MEMORANDUM

TO: Nell Donaldson, Planner
FROM: David Senus, P.E. & Ashley Auger, E.I.T.
DATE: September 20, 2012
RE: Pomeroy Street Construction, Level II Site Plan Application

Woodard & Curran has reviewed the Response to Comments on the Level II Final Site Plan Application for the Pomeroy Street extension located off of Bancroft Street in Portland, Maine. The parcel was previously approved for a Site Plan and Conditional Use Permit in August of 2005 by the City for a single family residence with attached synagogue; however, these permits have since expired. The current amended project consists of developing a single family home (Level I), an outsale lot to be sold to Square One Construction Inc. for possible development, and construction of approximately 200 linear feet of Pomeroy Street (Level II).

SHEET
7

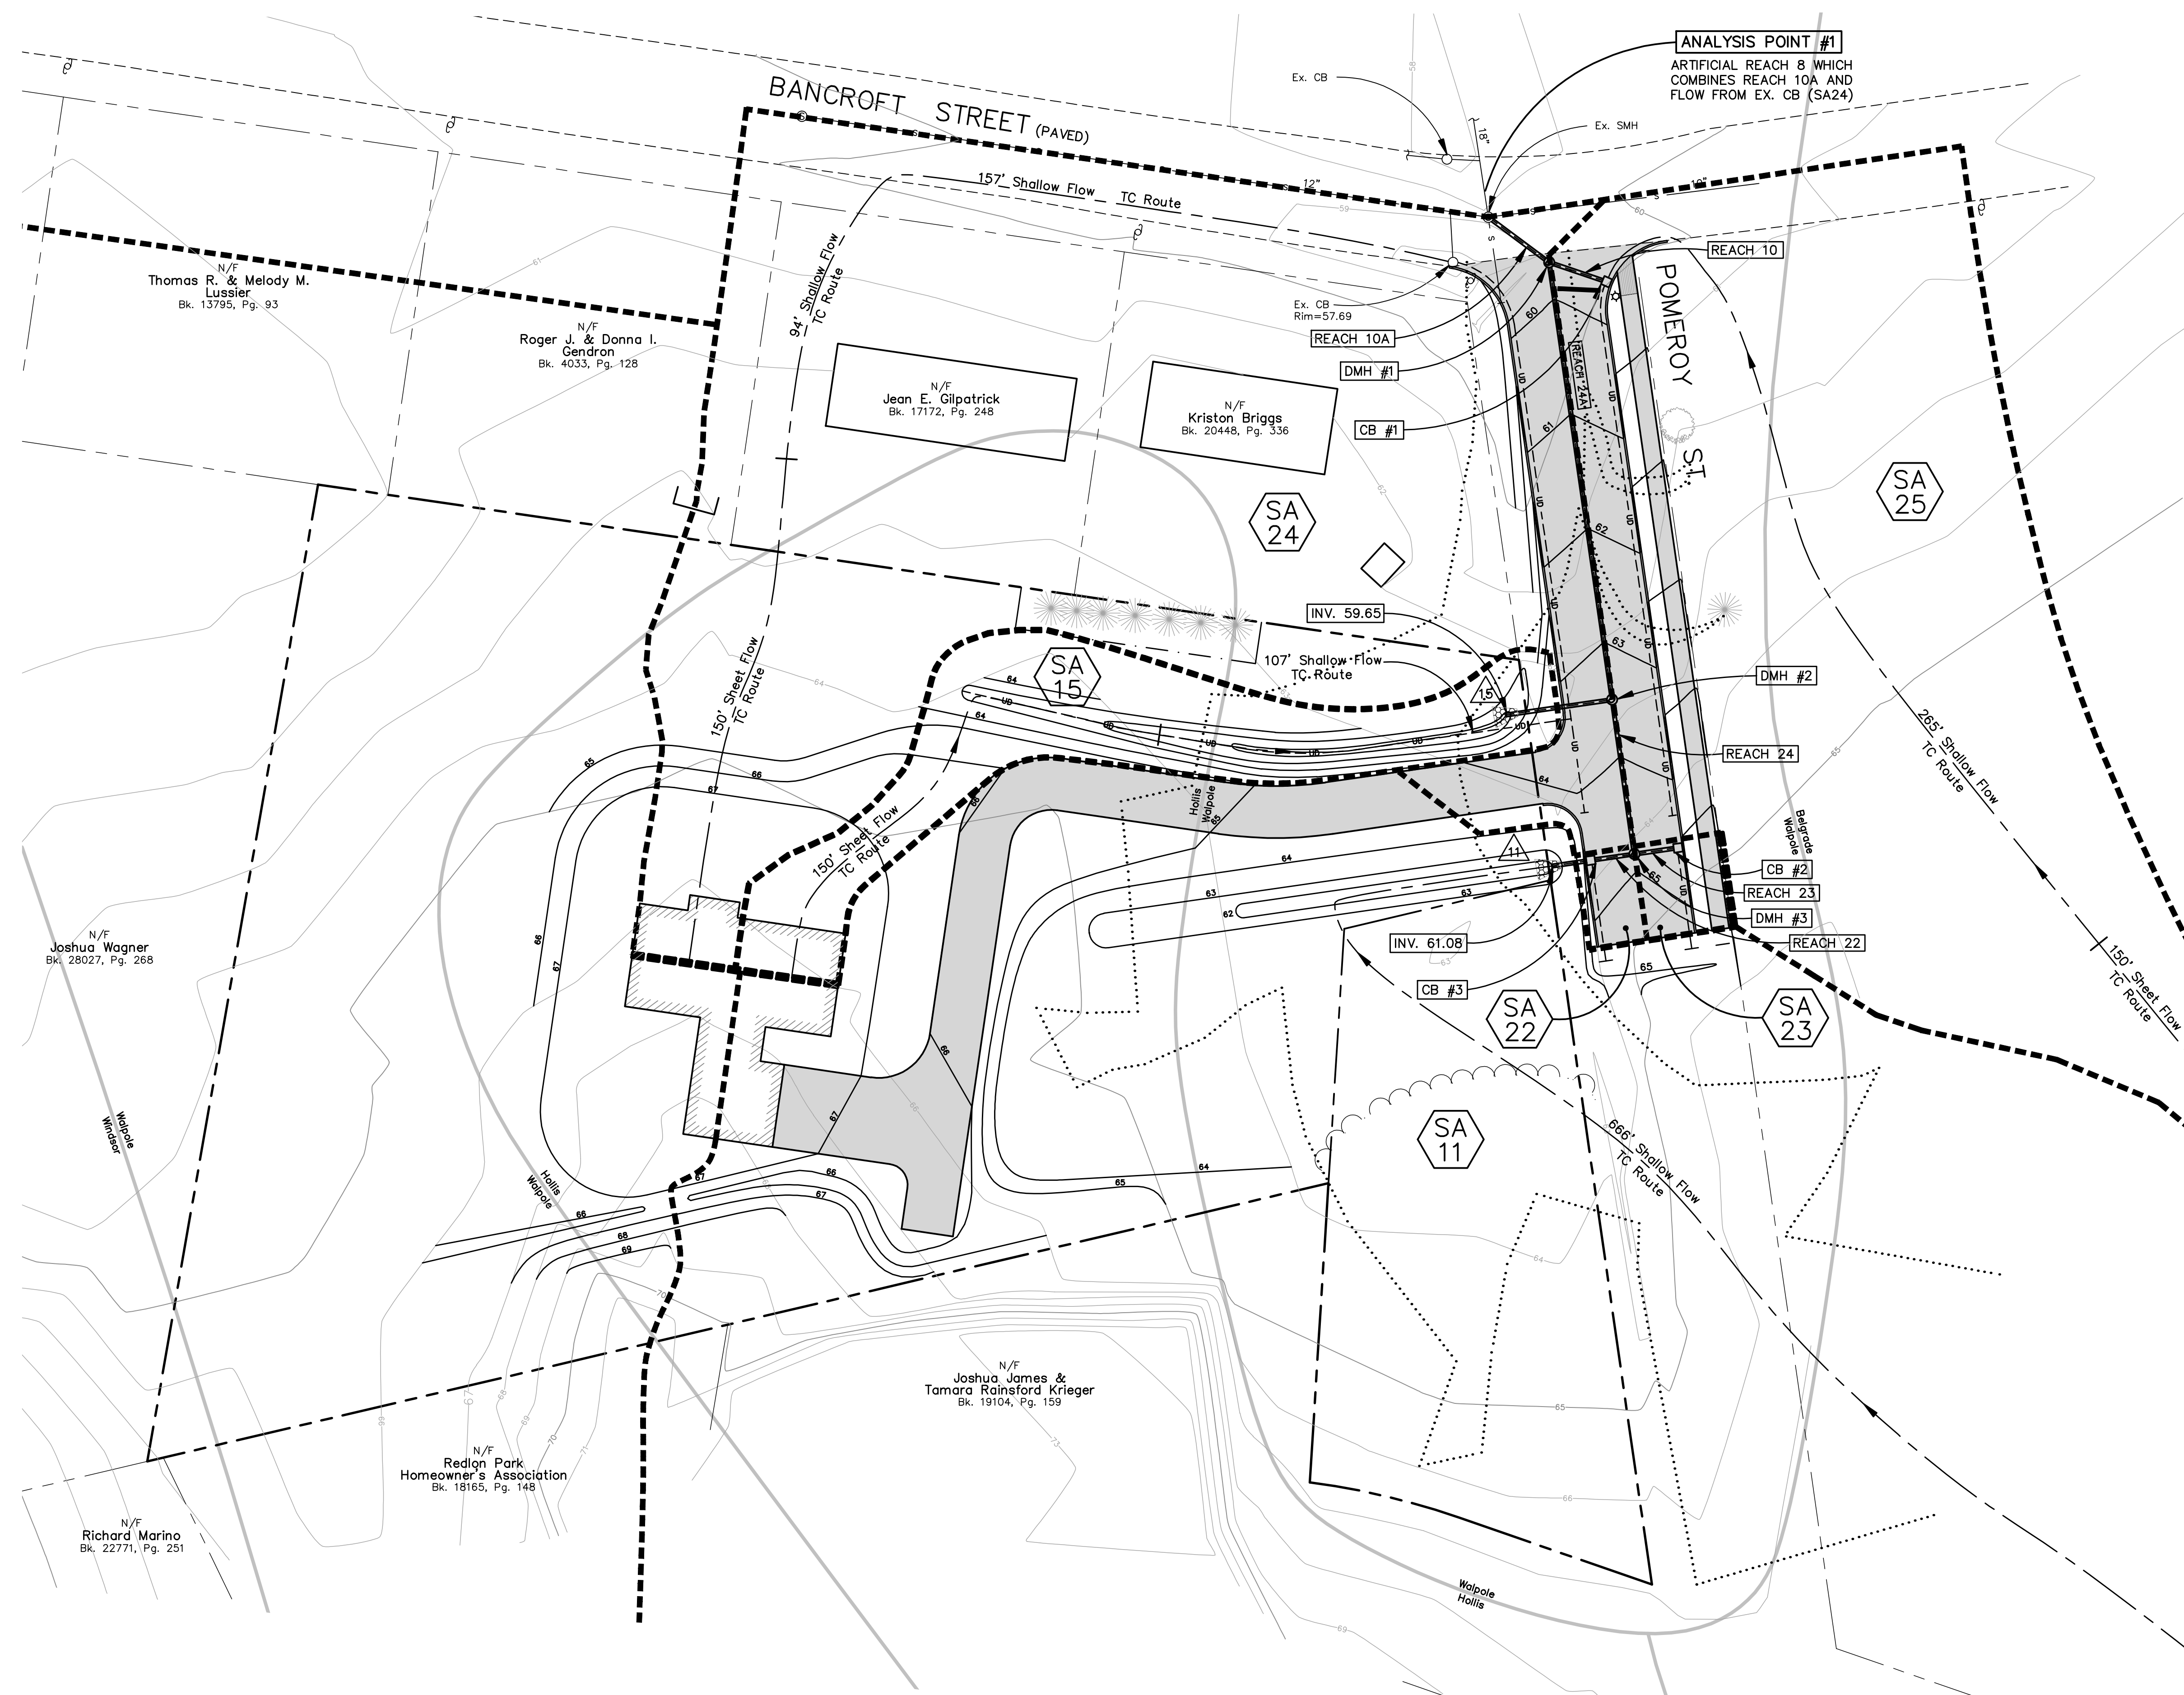
- i) The input parameters for Sheet Flow for SA-1 (Pre) and SA-11 (Post) should be the same, as this area will not change as a result of the project. **The time of concentration lines for SA-1 (Pre) and SA-11 (Post) are shown on Sheets 6 & 7. These Tc lines show a 150' length of SHEET flow at the far east edge of the drainage boundary. Because there are no proposed changes in this area, the HydroCAD model should reflect the same slope and cover type for this 150' length of sheet flow in the pre & post condition. Please revisit the model and adjust accordingly.**
